11 January 2012

MP10_0097 MOD 1
Spectator Precinct Royal Randwick
Section 75W Application
Response to Heritage Branch Comments

The S75W application was referred to the Heritage Branch of the Office of Environment and Heritage and comments, dated 16/12/2011, were received from Mr Vincent Sicari. The following comments are provided as a response to the points raised in this correspondence, which have been reproduced in italics.

Existing tree relocated
- 34

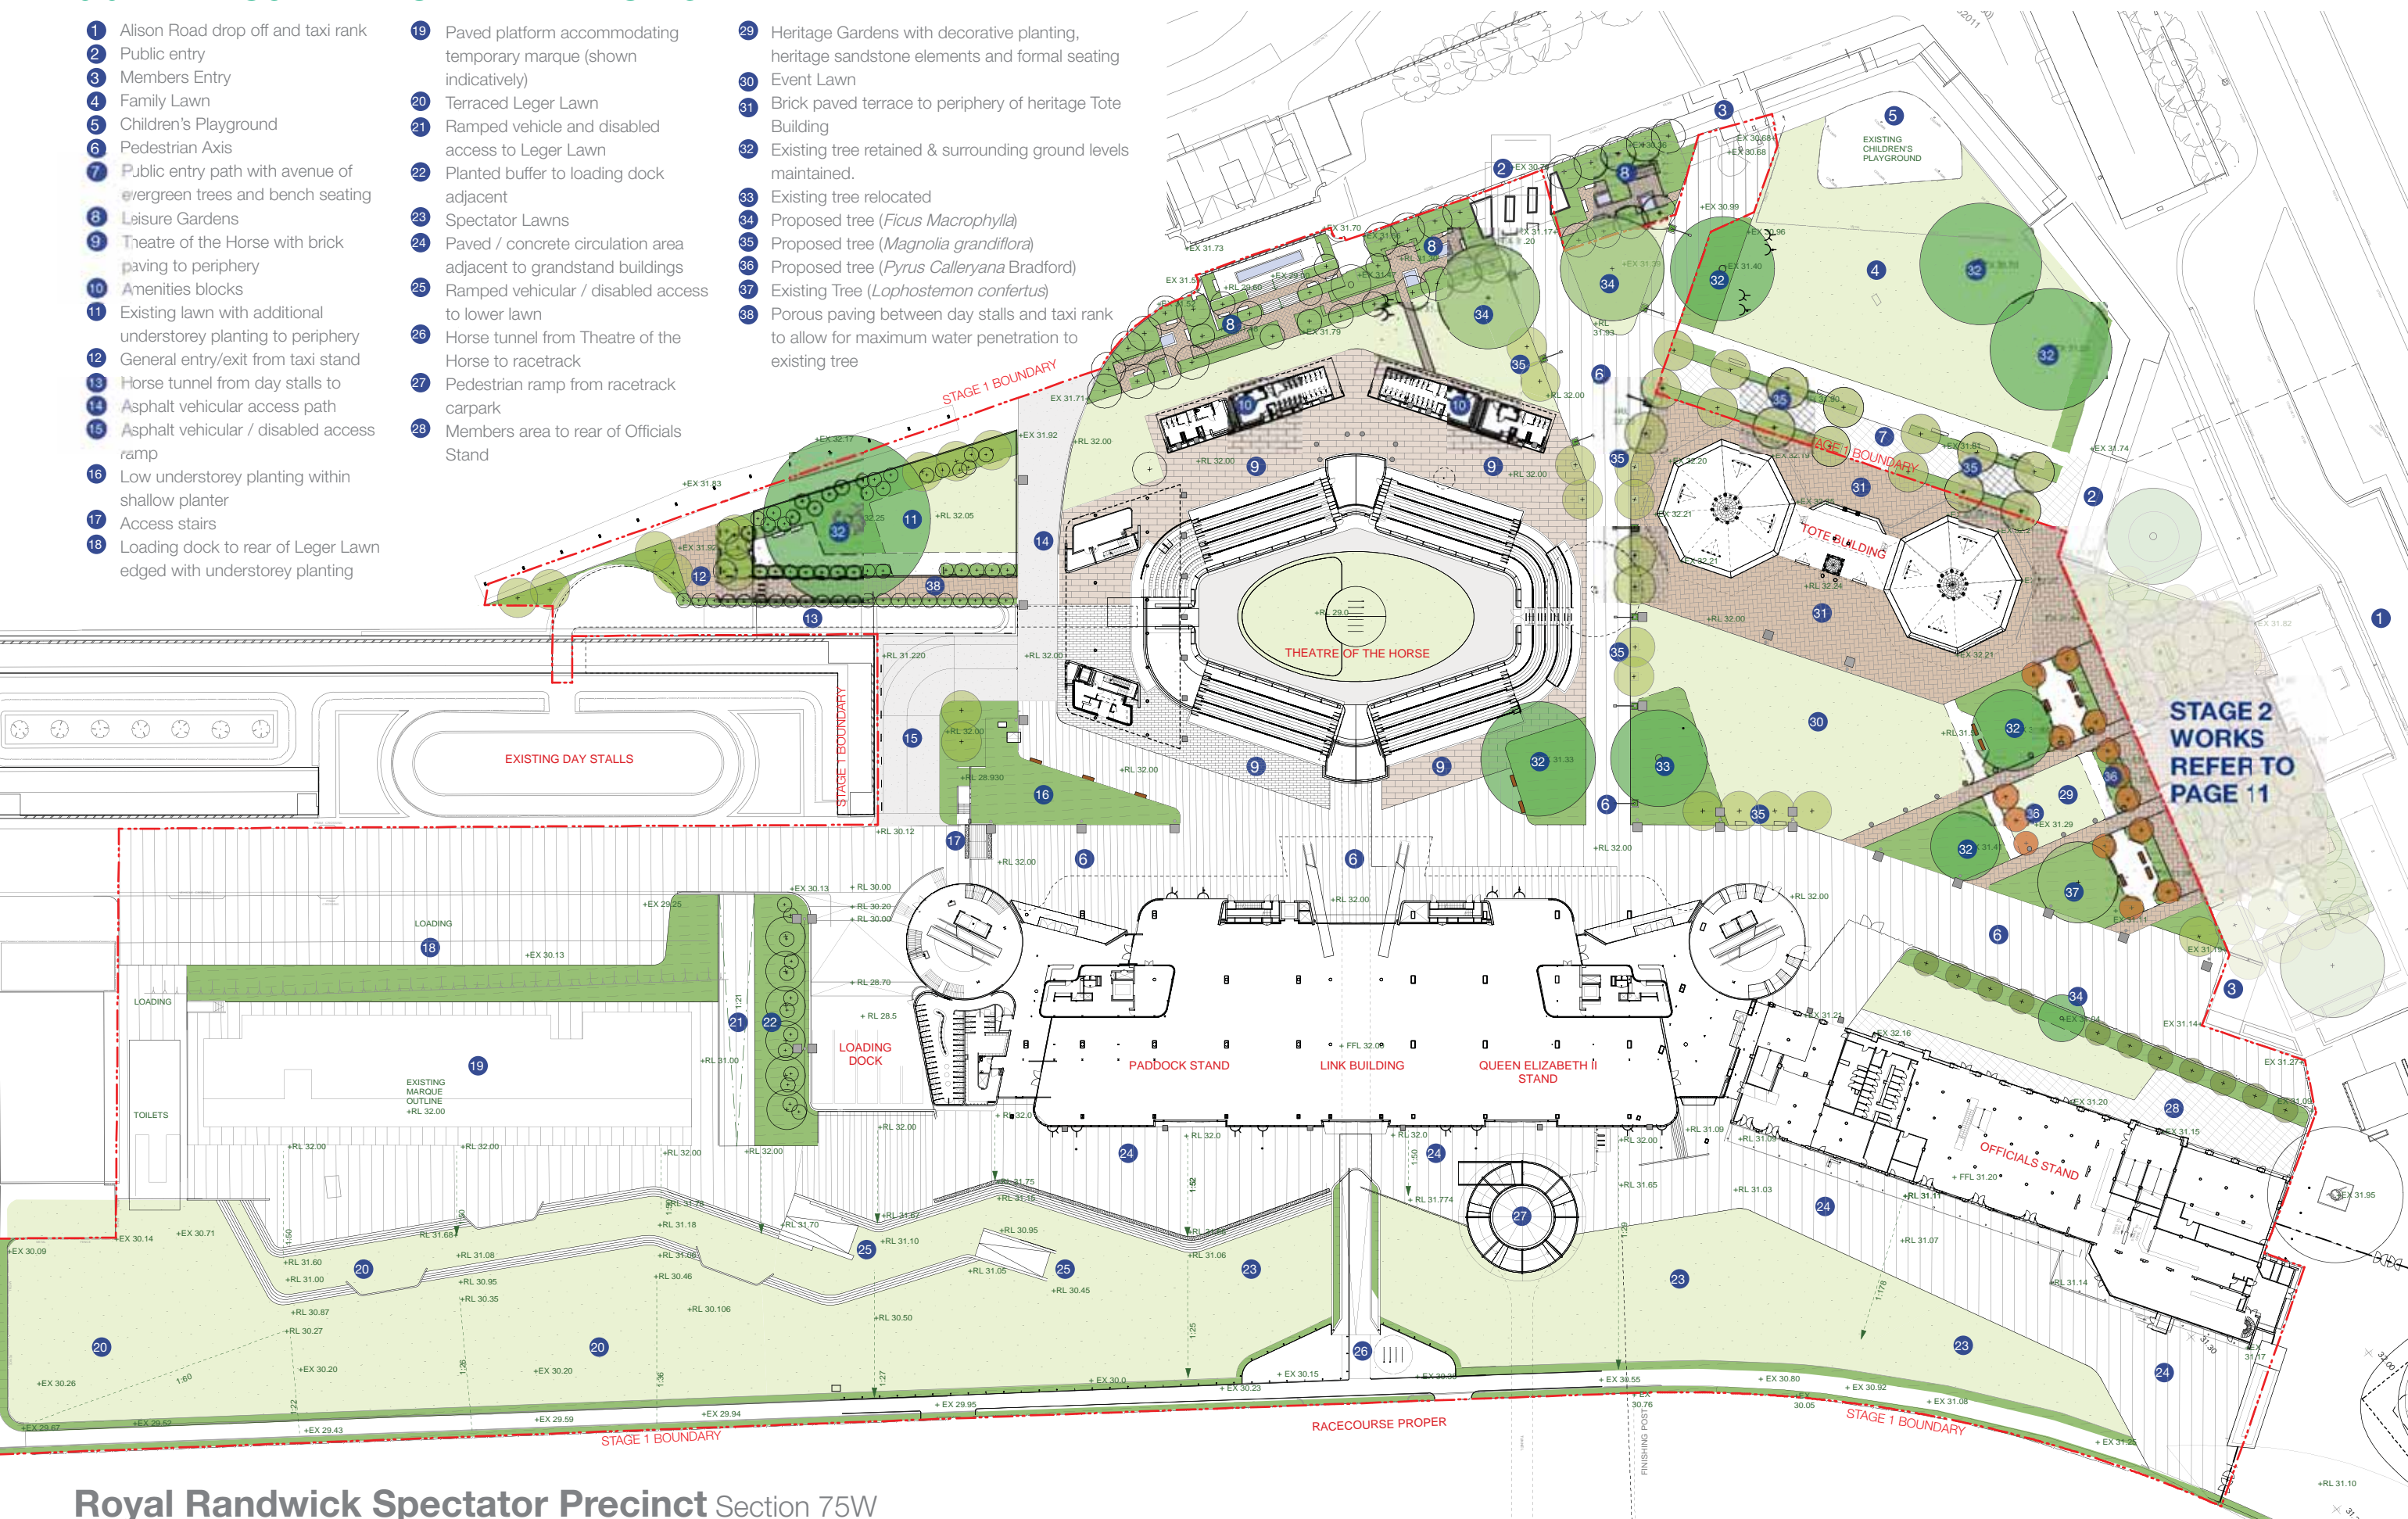
In regards to the removal and relocation of the tree which has been identified as having exceptional/high significance, the Heritage Branch accepts the comments of the project Arborist that the tree is constrained by its existing enclosure and will do better in the new location. The Heritage Branch does not object to the relocation of the tree. However, the HIS does not indicate where the tree is being relocated to therefore the Heritage Branch is unable to comment on the suitability of the new location. In relation to tree protection, consideration should be given to adopting applicable recommendations on page 12 of the Earthscape Horticultural Services Development Impact Assessment Report, dated September 2010, as specific consent conditions for the proposed development. The applicant should also be required to adhere to the guidelines in Section 7 'Protective Tree Zone' of the above report.

The landscape plan submitted with this application shows the new location for this tree.
